**Addendum No. 2**

RE: Contract ID: C202305

**Wake County (I-5114)**

I-440 From I-40 To US-64/264 Bypass

TYPICAL DETAIL OF BONDED OVERLAY
REMOVAL AT GORE AREA

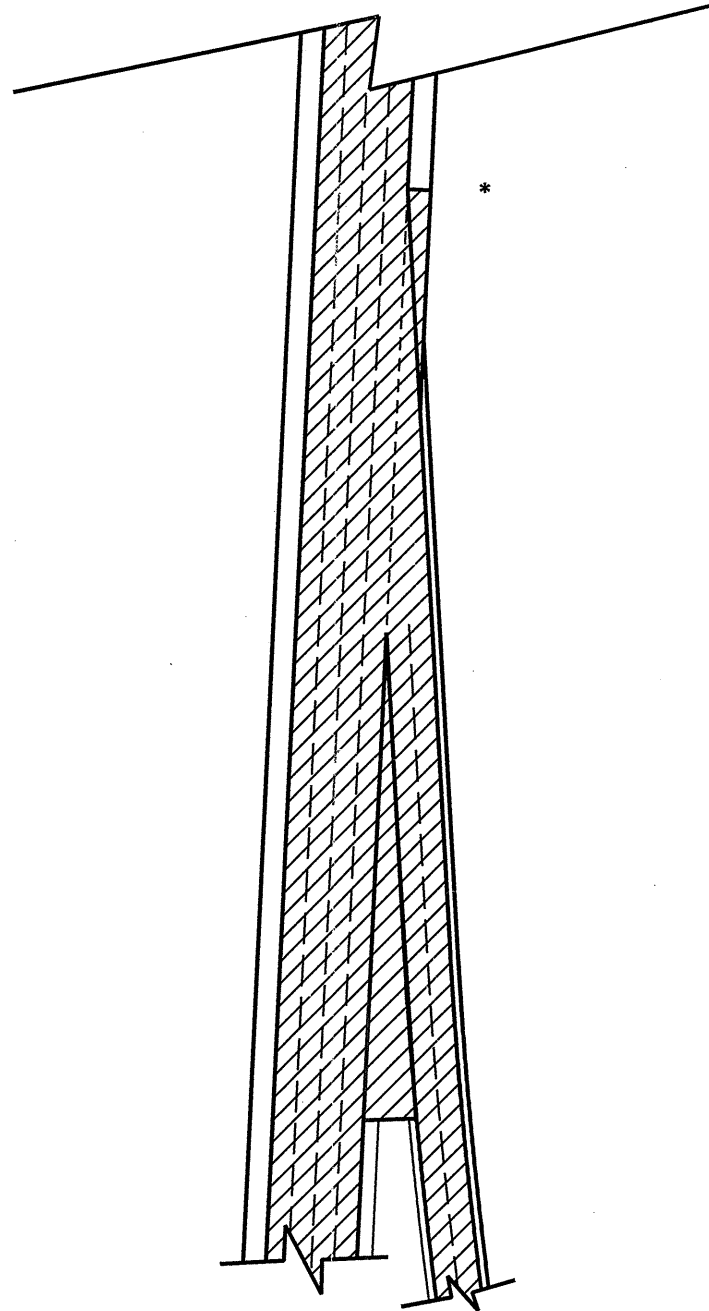
New Page Nos. 54-A, and 54-B have been added to include the project special provision entitled "Concrete Bonded Overlay Removal". Please staple New Page Nos. 54-A and 54-B after existing Page No. 54 in your proposal.

On Page No. 1 of the item sheets, by copy of this addendum, the following pay item is hereby revised: "4-1297000000-E-607 Milling Asphalt Pavement, 3" Depth (Quantity = 30,634 SY)" is revised to be "4-1891000000-E-SP Milling Concrete Bonded Overlay, 3" Depth (Quantity = 30,634 SY)". Also on Page No. 1 of the item sheets, by copy of this addendum the following pay item is hereby revised: "5-1297000000-E-607 Milling Asphalt Pavement, 4" Depth (Quantity = 68,679 SY) is revised to be "5-1891000000-E-SP Milling Concrete Bonded Overlay, 4" Depth (Quantity = 68,679 SY). The Contractor's bid must be based on these revised pay items. The Contract will be prepared accordingly.

Perform the work of removing the existing concrete bonded overlay in its entirety at the locations shown on the plans. After the milling operation, clean the remaining surface, remove any residual concrete bonded overlay, and dispose of the removed material prior to tacking and paving.

Mechanically remove the concrete bonded overlay from the underlying concrete pavement by either milling or grinding to the minimum depths indicated on the plans to remove the entire bonded overlay without significant overcutting. Multiple milling passes may be required. This work will include, but is not limited to, milling and remilling the concrete bonded overlay at the locations, depths, widths, and details shown on the plans; thoroughly cleaning the milled surface; loading; hauling; and disposal of the milled material.
